**From:** Veronique Bensadou <[REDACTED]>  
**Sent:** 19 January 2021 17:12  
**To:** Raymond Cole <[Raymond.Cole@arun.gov.uk](mailto:Raymond.Cole@arun.gov.uk)>; Planning <[Planning@arun.gov.uk](mailto:Planning@arun.gov.uk)>  
**Subject:** Planning Appl ref. F/4/20/OUT: Representation letter

**Application Ref.:** F/4/20/OUT

**Proposal:** Outline planning application (with all matters reserved except for access) for the development of up to 1,500 dwellings (Use Class C3), 60-bed care home (Use Class C2), up to 9,000 sqm of employment floorspace (Use Classes B1), local centre of up to 2,350 sqm including up to 900 sqm retail/ commercial (Use Classes A1-A5) and 1,450 sqm community/ leisure floorspace (Use Classes D1-D2), land for a two-form entry primary school (Use Class D1), public open space, allotments, new sports pitches and associated facilities, drainage, parking and associated access, infrastructure, landscape, ancillary and site preparation works, including demolition of existing buildings and part removal of existing runway hardstanding.

**Location:** Land at Ford Airfield Ford

Figure 3: Potential noise sensitive areas

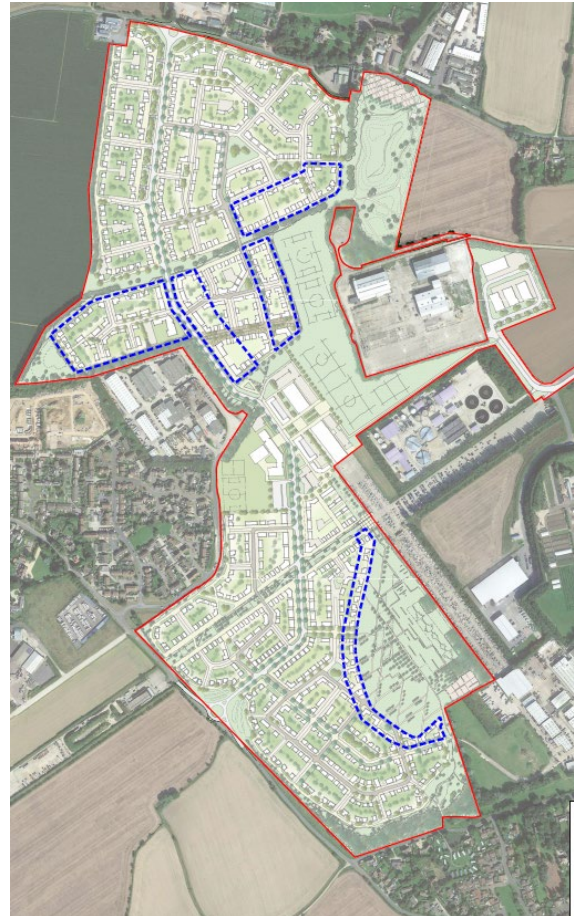
The layout of the proposed dwellings at The Landings is not likely to provide the 10 dB attenuation assumed by 24 Acoustics. It is not likely to be practical to have no windows to habitable rooms facing the Ford CTP site or industrial noise sources. To design a development that would consistently achieve a 10 dB level difference between front and rear façades is unlikely to be possible in this setting. This level of attenuation would likely require continuous rows of terraced housing with no habitable rooms facing the Ford CTP site. We would therefore suggest that the Local Authority conditions this requirement as it is key to achieving reasonable amenity for future residents.

We request that the Applicant for The Landings submits a detailed site layout and scheme of sound insulation, prior to any works on site, to demonstrate how impacts and the likelihood for complaints can be reduced to a minimum for future residents. This

should also demonstrate how the layout has achieved the 10dB attenuation through layout with no habitable rooms facing surrounding industrial noise sources.

Figure 4: Typical illustrative plan showing noise mitigation principles, subject to detailed noise assessment and layout planning at reserved matters stage. Not for approval of detailed block layout or type/mix of housing.

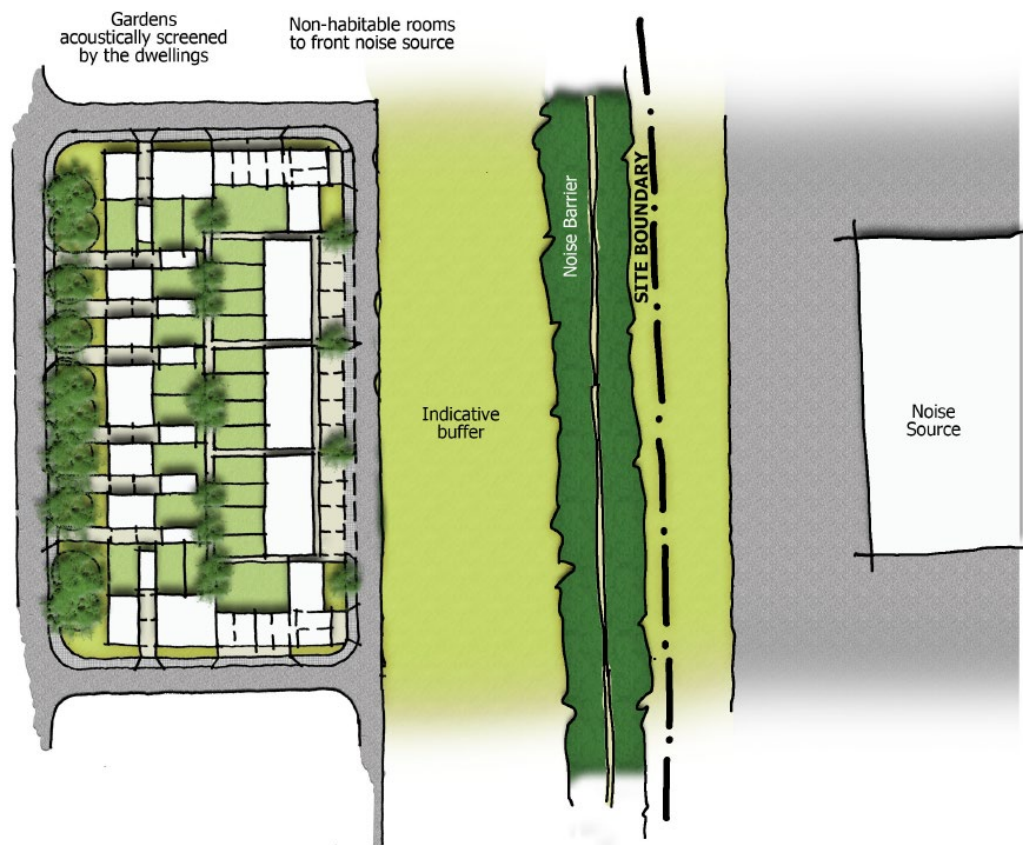
- 10 dB attenuation of noise levels has been assumed by the application of the following mitigation measures:
  - 'Gardens located to not face the industrial sources, i.e. acoustically screened by the dwellings;

- Orientation of dwellings so that no habitable rooms are directly facing the industrial sources'
- The daytime and night-time background noise levels measured by 24 Acoustics in July 2018 (detailed for measurement location 8 in technical report R6930-3 Rev 2) have been used for assessment of the rating levels.
